From: [REDACTED]
To: [A12chelmsfordA120](#)
Cc: [Planning Services](#); [REDACTED]
Subject: Colchester City Council: A12 DCO Written Questions from Inspectorate - Deadline 2 Submission
Date: 10 February 2023 16:43:33
Attachments: [image001.jpg](#)
[image002.jpg](#)
[image003.png](#)
[image004.png](#)
Importance: High

We have set out below our response to EXQ1: 20 January 2023, as follows:

Our response is based upon the Chapter 6 Air Quality document and figure 6.9 of the environmental statement.

FIGURE 6.9

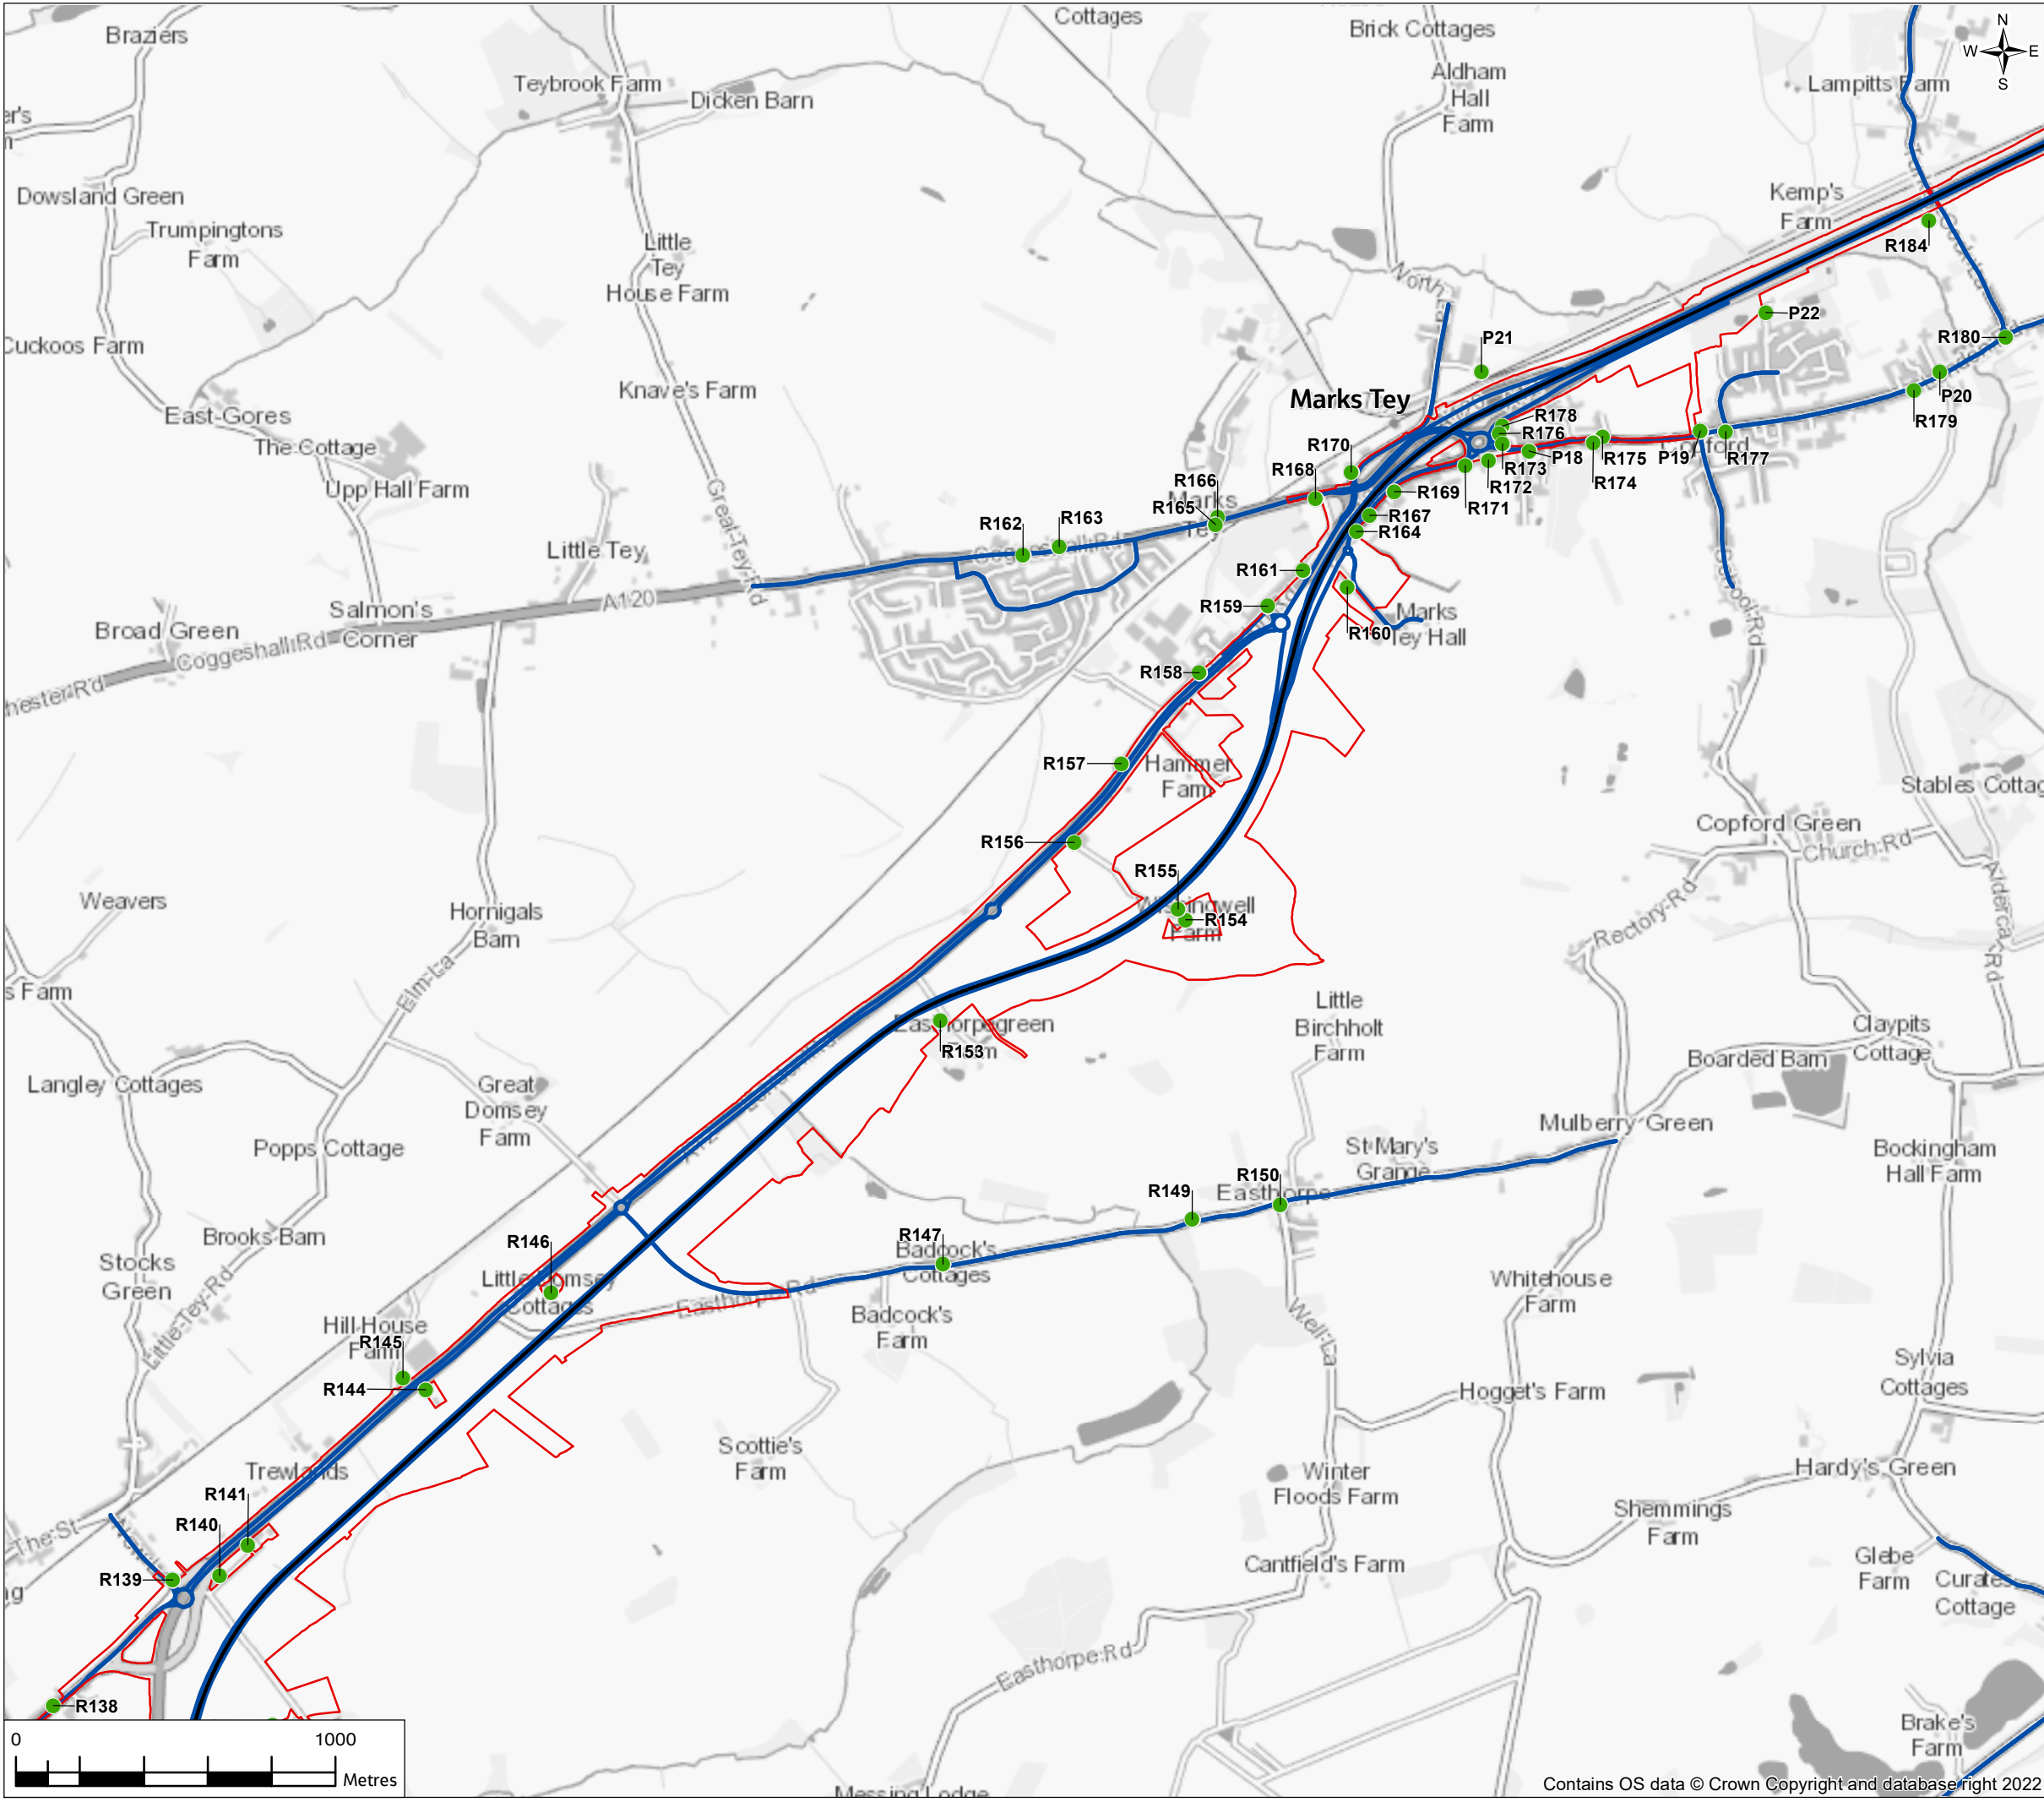
- 2.01 The Dust Management plan complies with guidance and CoCC is satisfied with the proposed control measures.
- 2.03 Figure 6.9 identifies modelled receptors points along the A120 (R162, R163, R165, R166 and R168). However, Figure 6.9 and Chapter 6 Air Quality neglect to provide modelled concentrations either in tabular or graphical representation for the base 2019, do minimum or do something scenarios. It is not clear what local features have been input for these locations: For R162 & R163 it is reasonable to consider the use of a partial street canyon within the model which could affect modelled outcomes significantly. With this fundamental information missing, CoCC cannot determine that air quality in Marks Tey will not be affected.
